THE VICTORIAN SOCIETY
The champion for Victorian and Edwardian architecture

19 August 2016

RE: 20-24 Cross Church Street, Huddersfield (Grade II, C19); application for the extension of the Kingsgate Shopping Centre and the partial demolition of listed buildings

PROPOSED SECTION B-B, THRU NEW RETAIL EXTENSION & CINEMA

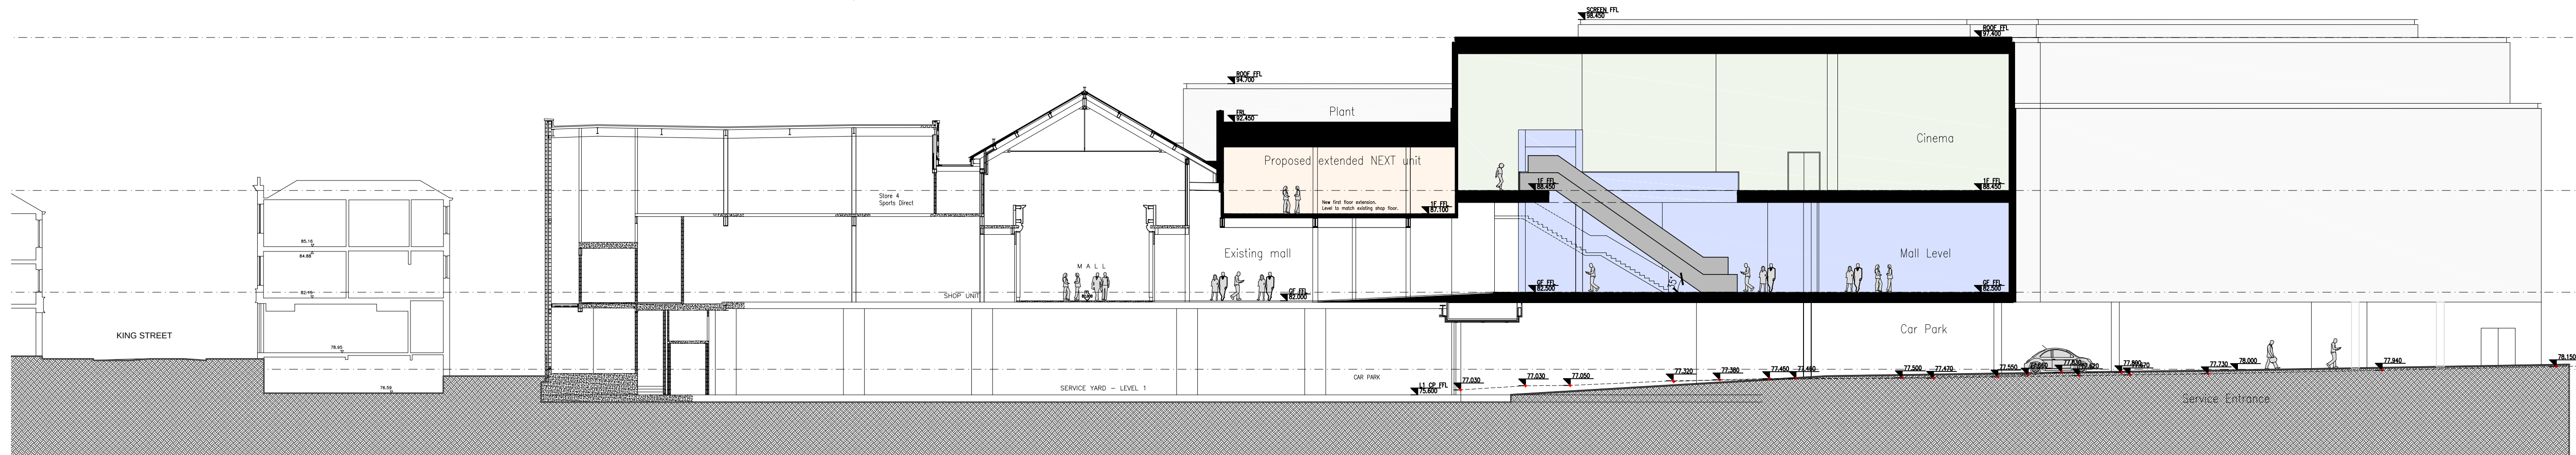
In addition, we support Historic England's comments concerning the likely adverse impact on the Conservation Area and the setting of numerous listed buildings caused by the sizeable bulk of the proposed cinema extension. It would be highly conspicuous and would represent a considerable departure from the distinctive and prevailing scale and grain of the Conservation Area.

Content	PROPOSED CANOPY		
Client	WD KINGSGATE LTD		
Project	KINGSGATE LEISURE		
Date	MAY 2016	Drawing Scale	1:25@ A1, 1:50@A3
Paper size	A1	Drawn by	HB
Project Code	756F	Drawing No.	PL-16
		Revision	B

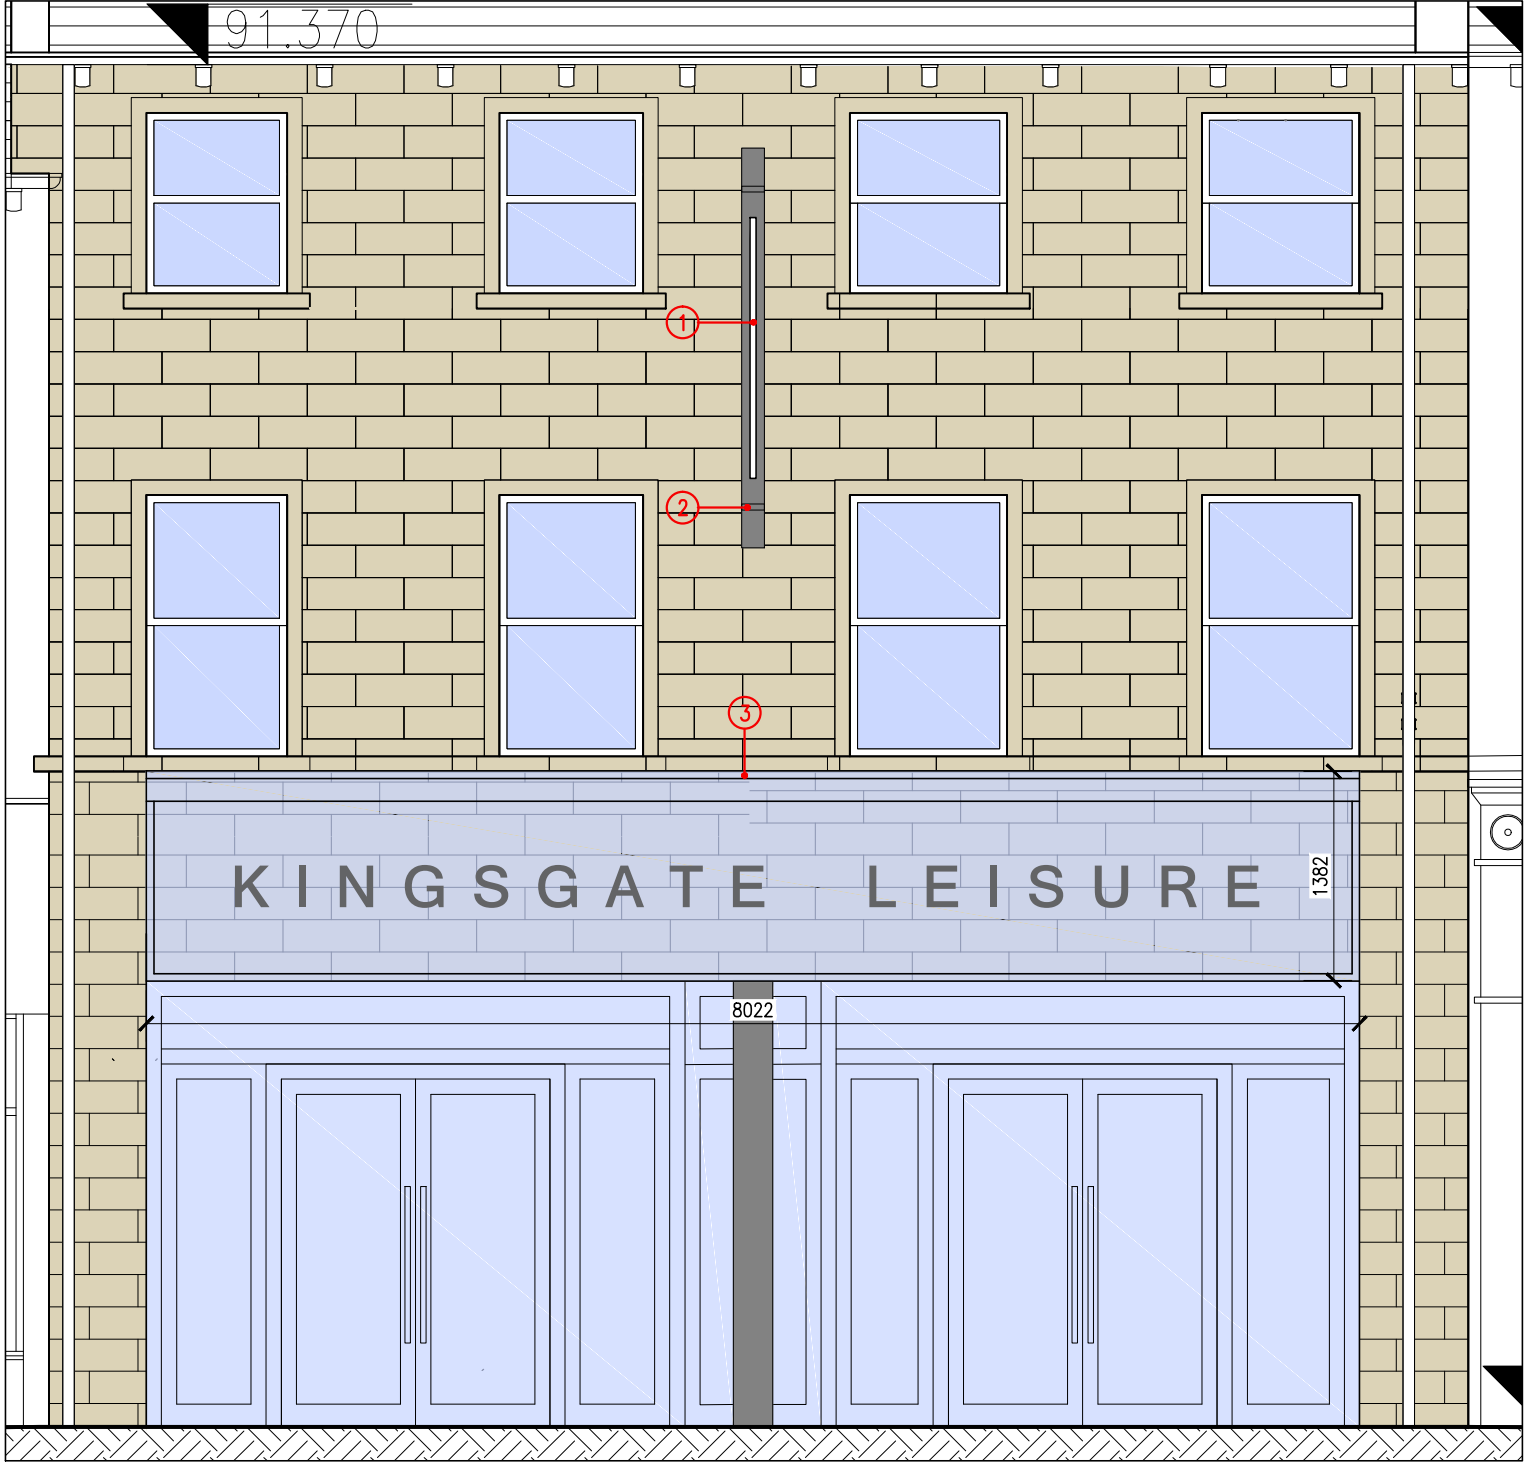
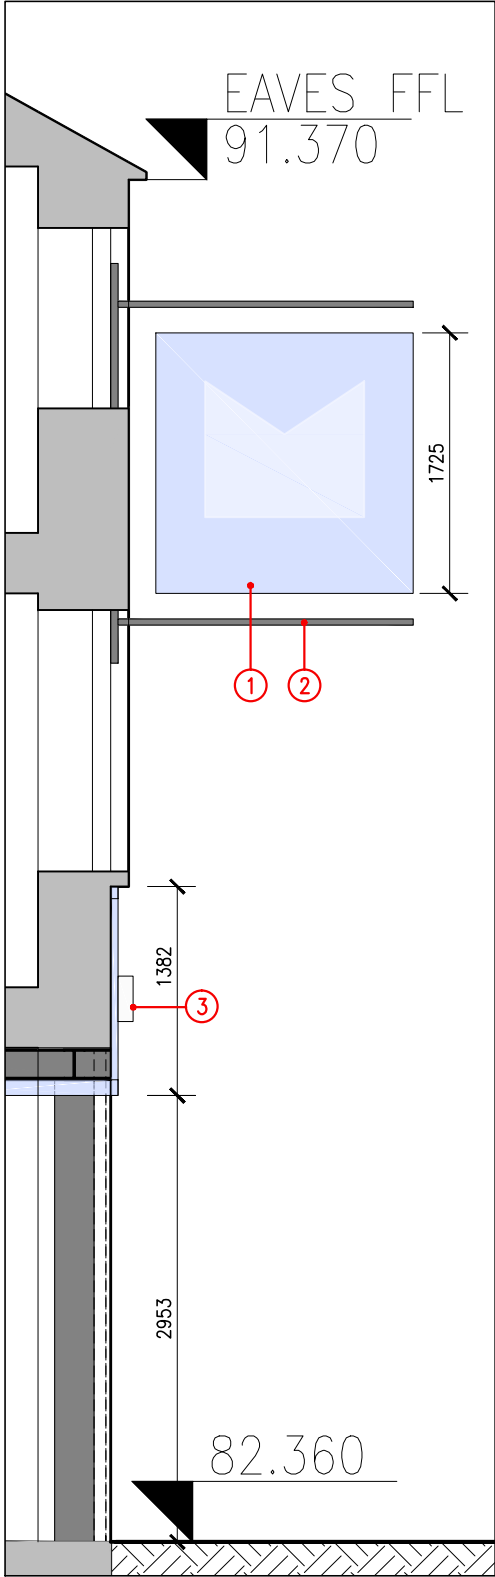
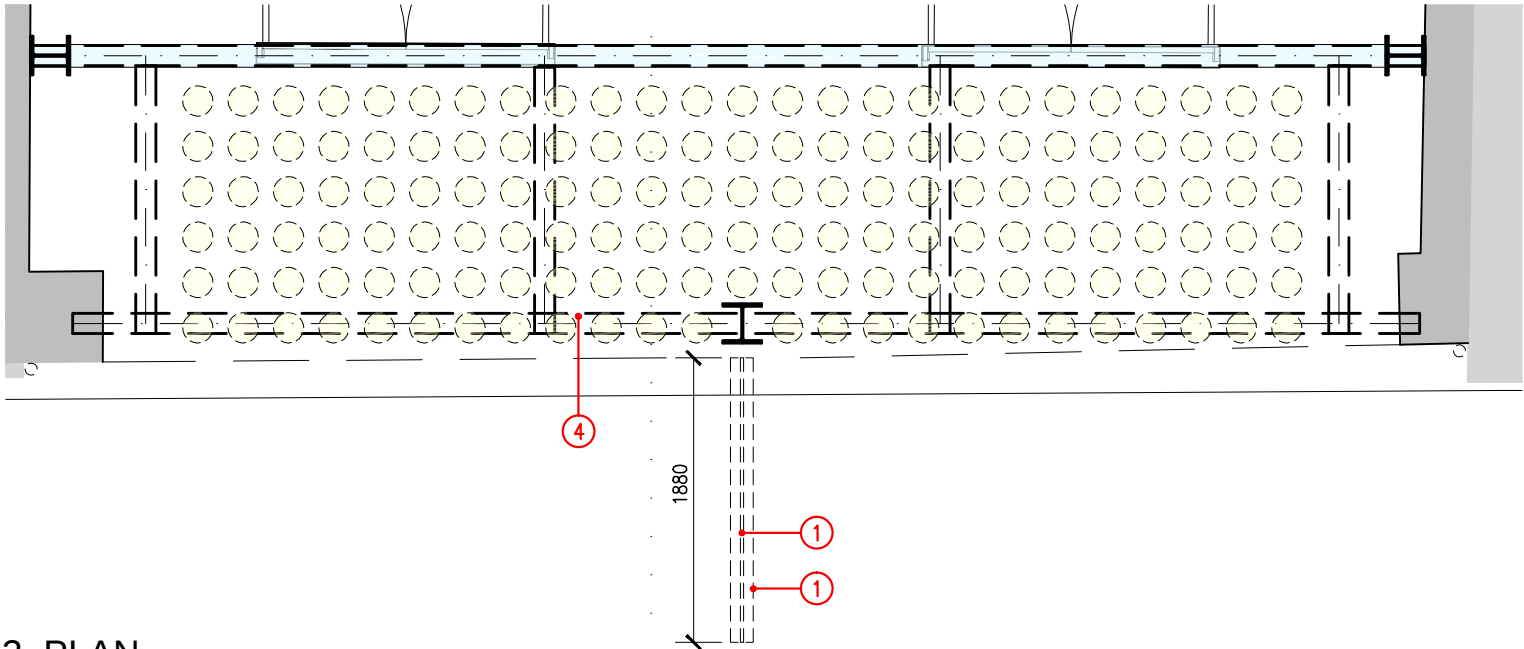
We **object** also to the crudely detailed canopy proposed to the front of 20-22 Cross Church Street, which would be visually obtrusive and overbearingly large. It is without precedent in the street and would detract markedly from the historic character and rhythm of this part of the Conservation Area. It should be omitted from the scheme.
